29 March 2010

Re: Major Project 08_0116 – Civil Works Stage 2 – Potts Hill Reservoir Site

I write in response to DECCW's letter of 3rd February 2010, which contained a number of comments to the Department of Planning on the Potts Hill Major Project (MP 08_0116) for Civil Works Stage 2. This letter provides a response solely relating to matters relevant to allow the proposed Conservation Agreement on the Sydney Water retained lands to proceed to exhibition.

POTTS HILL RESIDENTIAL PRECINCT
CONCEPT STORMWATER LAYOUT
SHEET 1 OF 2

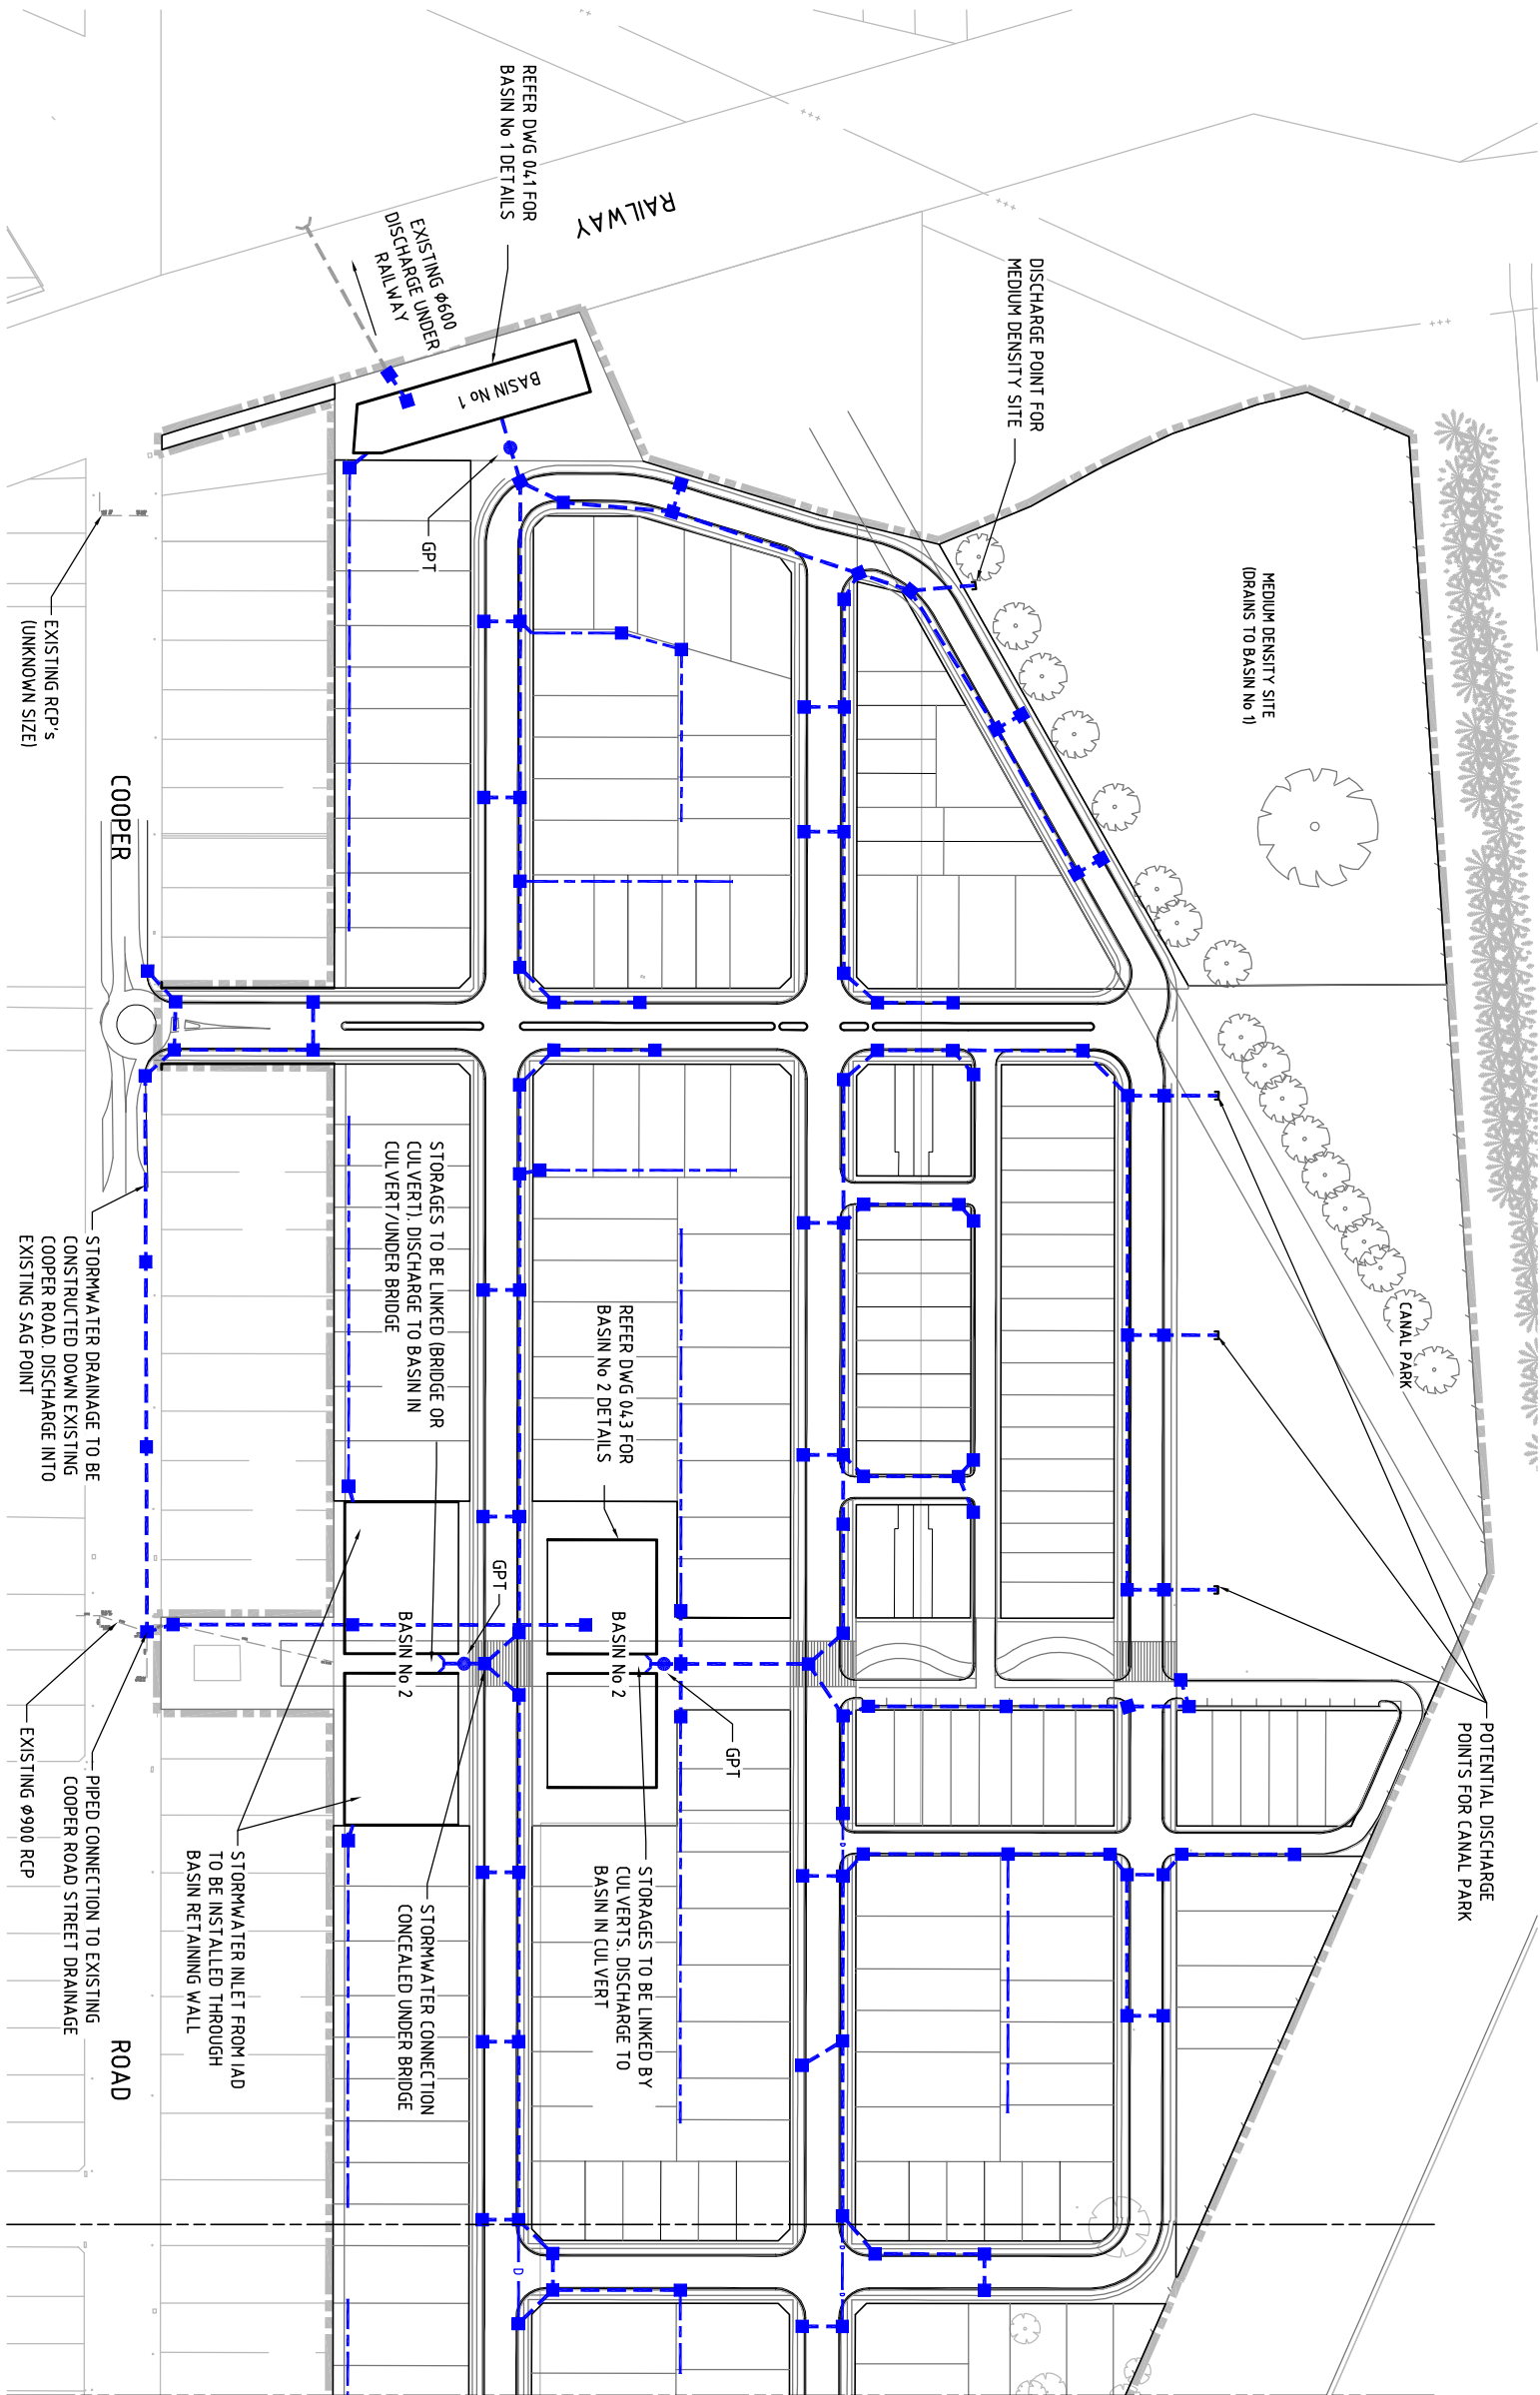
Landcom acknowledges DECCW's request that infrastructure, including all stormwater (eg. overland flow channel/swale), fencing and earthworks be removed from the Conservation Agreement lands.

1. Vegetation intended to be retained to the north of the stormwater detention basin in the Brunker Road Park (basin no. 3) being impacted by batters associated with this basin. DECCW recommends that the offset ratio is recalculated excluding this vegetation.
2. Seeking advice on changes in the boundaries of the Conservation Agreement lands and a reduction from 5.24ha to 4.99ha of EECs within these lands.
3. The Ecological Assessment (page 17) identifying that 0.24ha of Cumberland Plain Woodland (CPW) will be contained within the Conservation Agreement lands, and that this vegetation should be excluded from the offset ratio calculations.

Landcom agrees to remove all proposed infrastructure from the Conservation Agreement lands, and to amend all plans to exclude all infrastructure from the Conservation Agreement lands.

1. On review, it is acknowledged that there will be considerable disturbance to the vegetation to the north of basin no. 3. The area of additional vegetation affected, beyond that previously being treated as a loss, is 0.05ha. This vegetation will be treated as a loss for the purposes of the revised offset calculation (below).
